Our Ref: SSD 7388 Mod 7

**Modification 7 IMAX Redevelopment (SSD 7388 Mod 7)
Request for Additional Information**

I refer to the Response to Submissions for the IMAX Redevelopment Modification 7 (SSD 7388 Mod 7). After careful consideration, the Department is requesting that you provide additional information.

Noise Monitoring Data – Millennium Towers Background Noise Monitoring

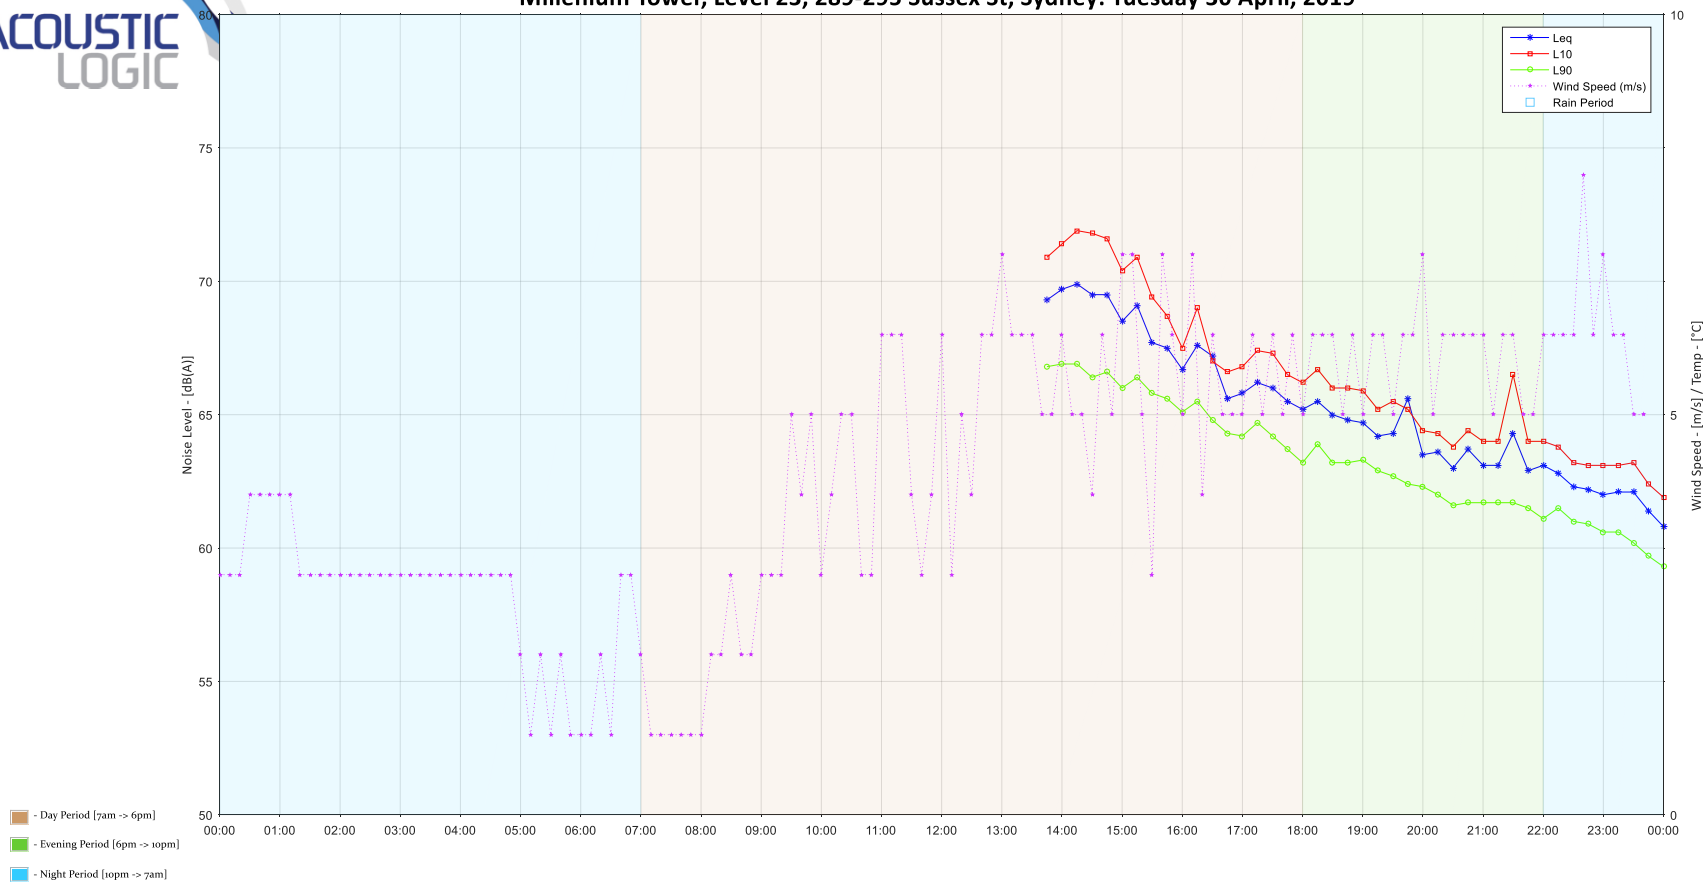
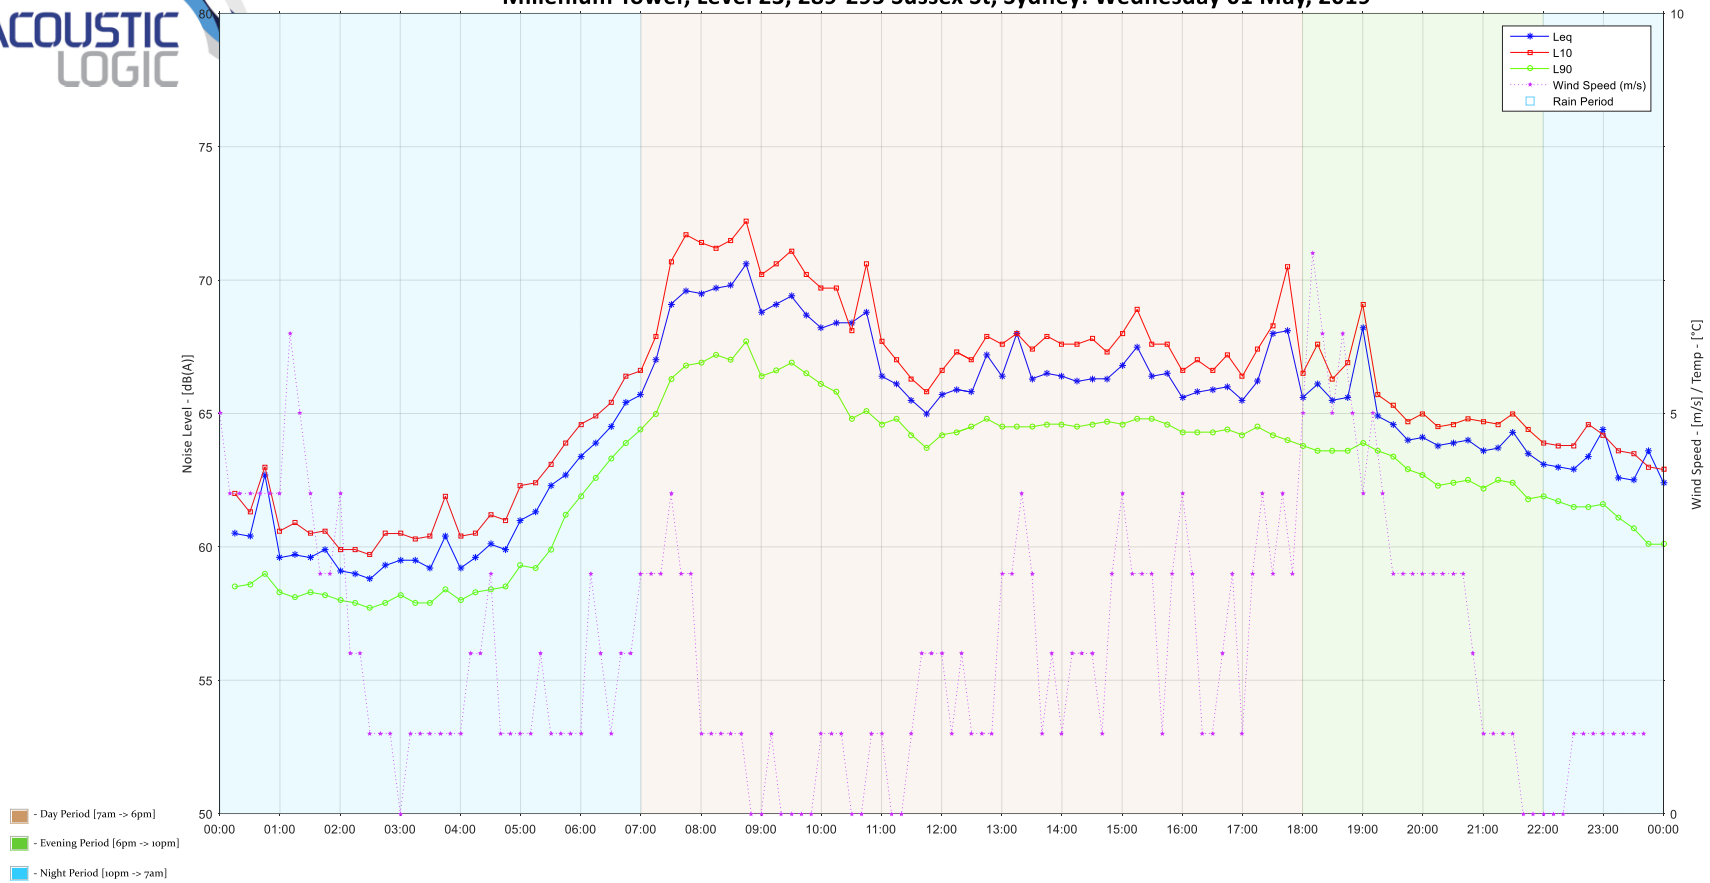
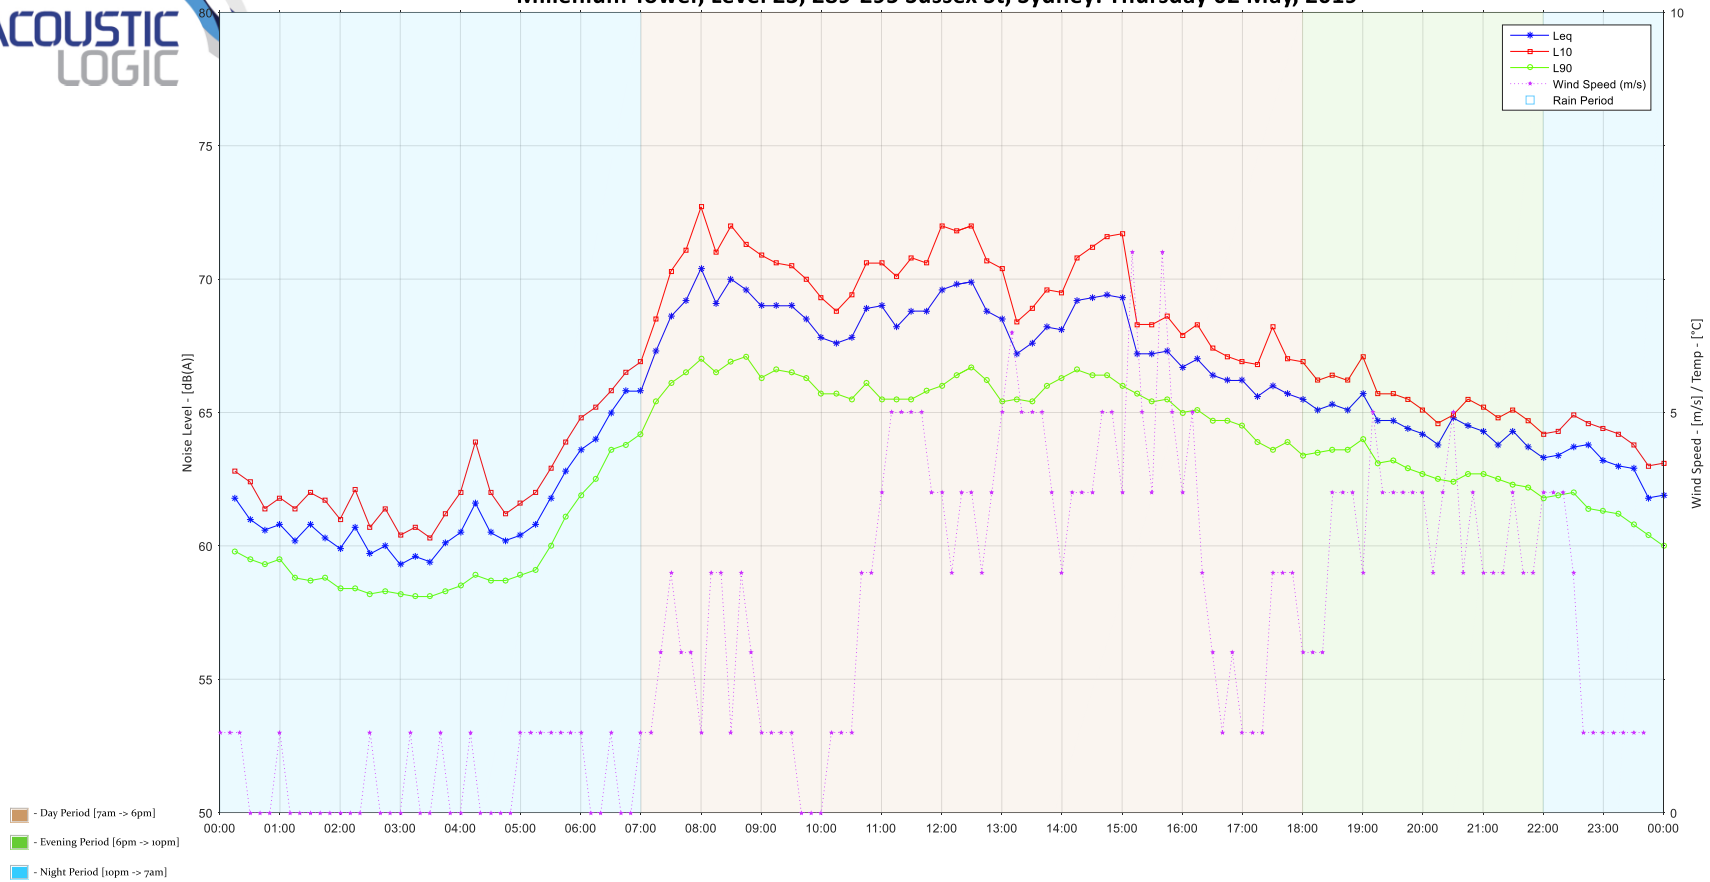
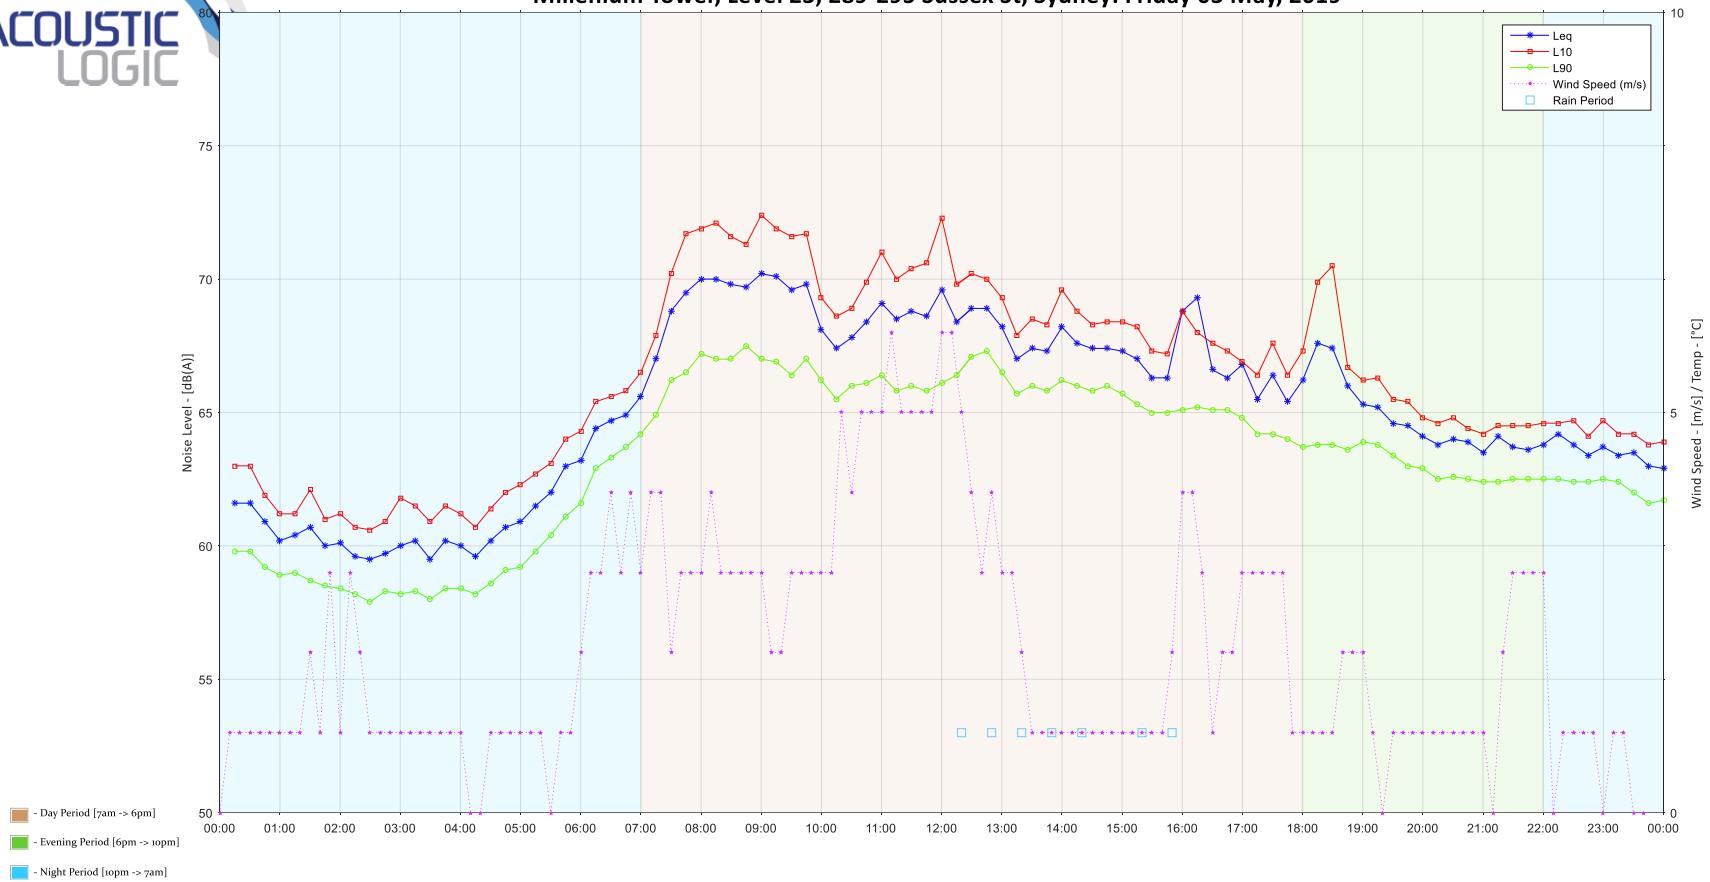
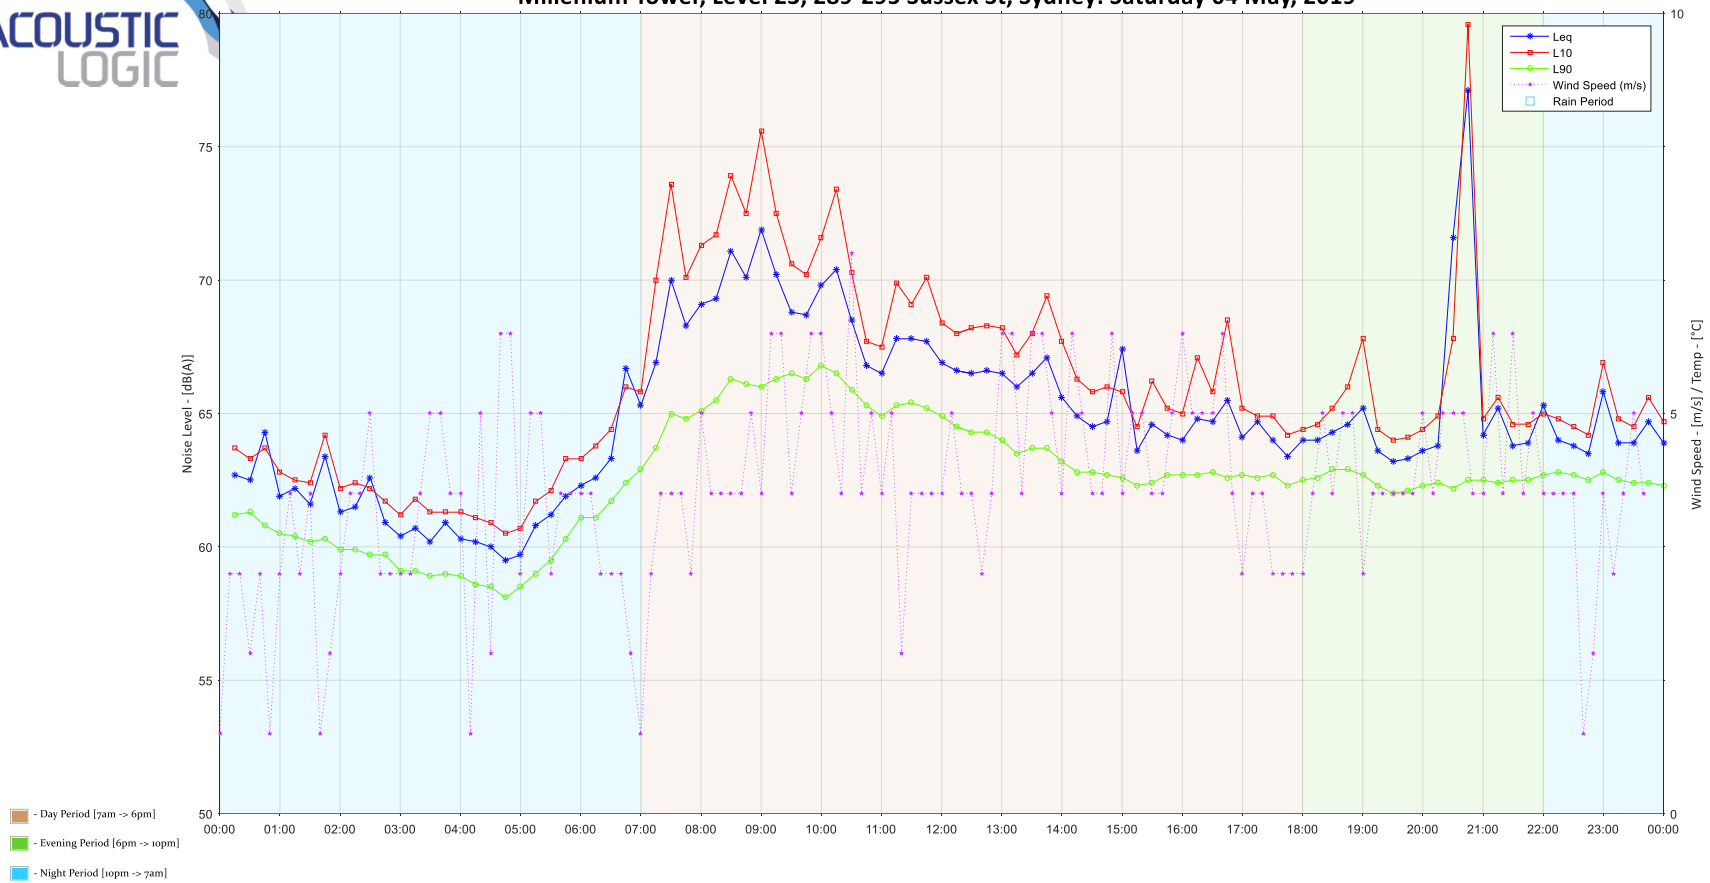
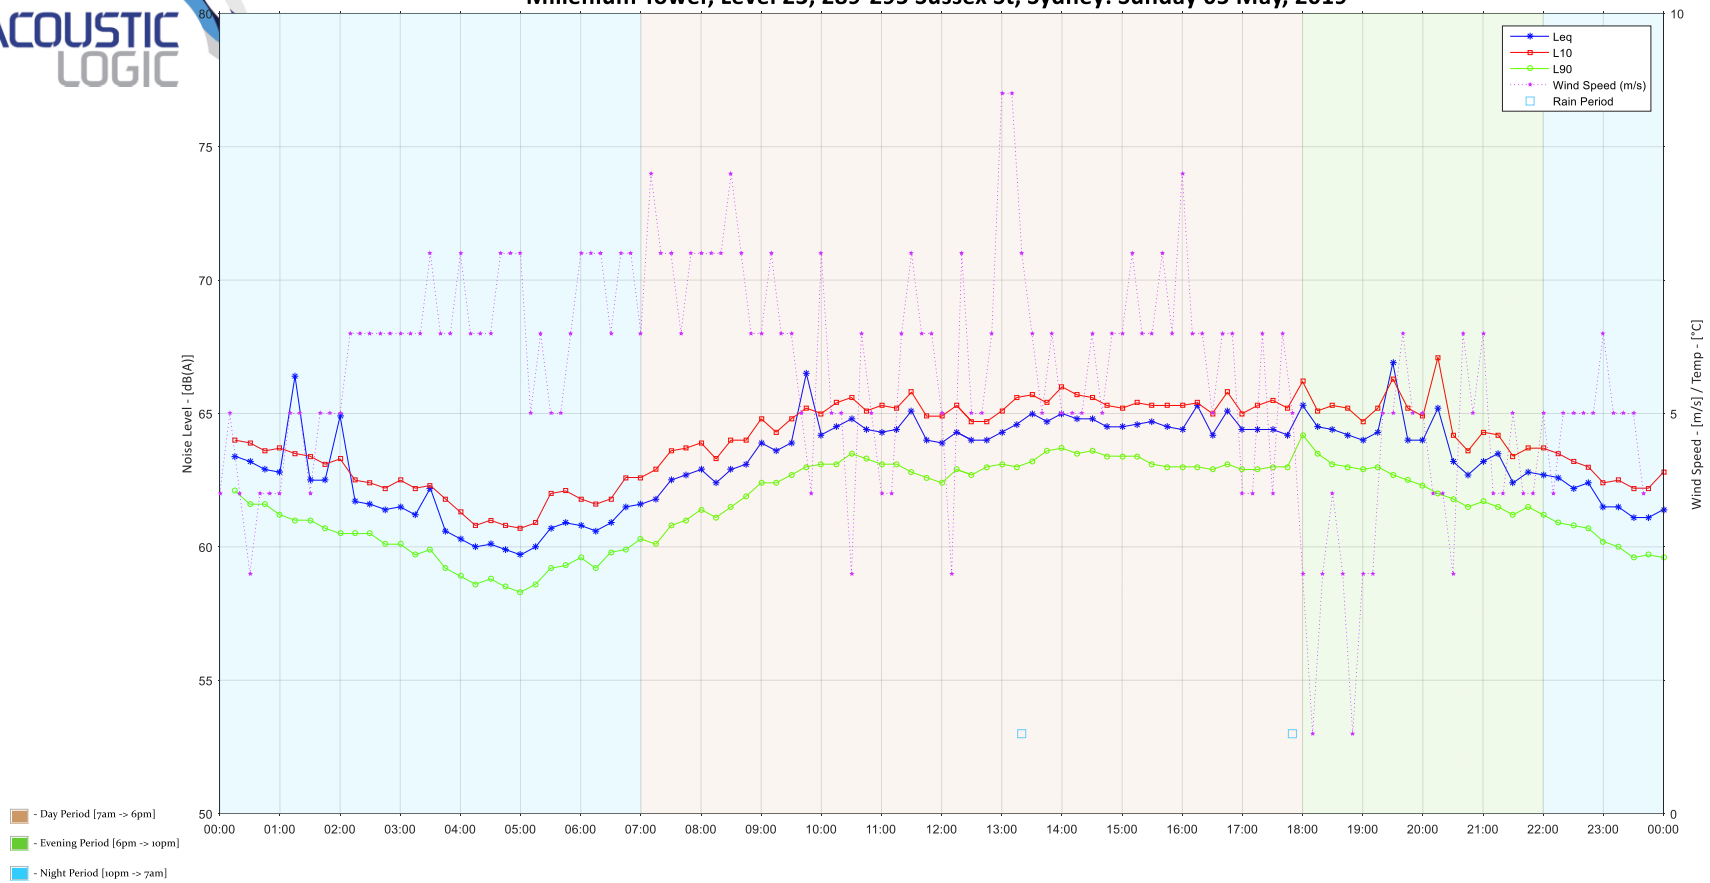
In order to assess whether the proposed noise limits for the pool/bar area are appropriate, the Department requires the submitted noise report to be updated to include background noise measurements from the nearest sensitive residential receivers, for both usage periods (7am to midnight and midnight to 7am).
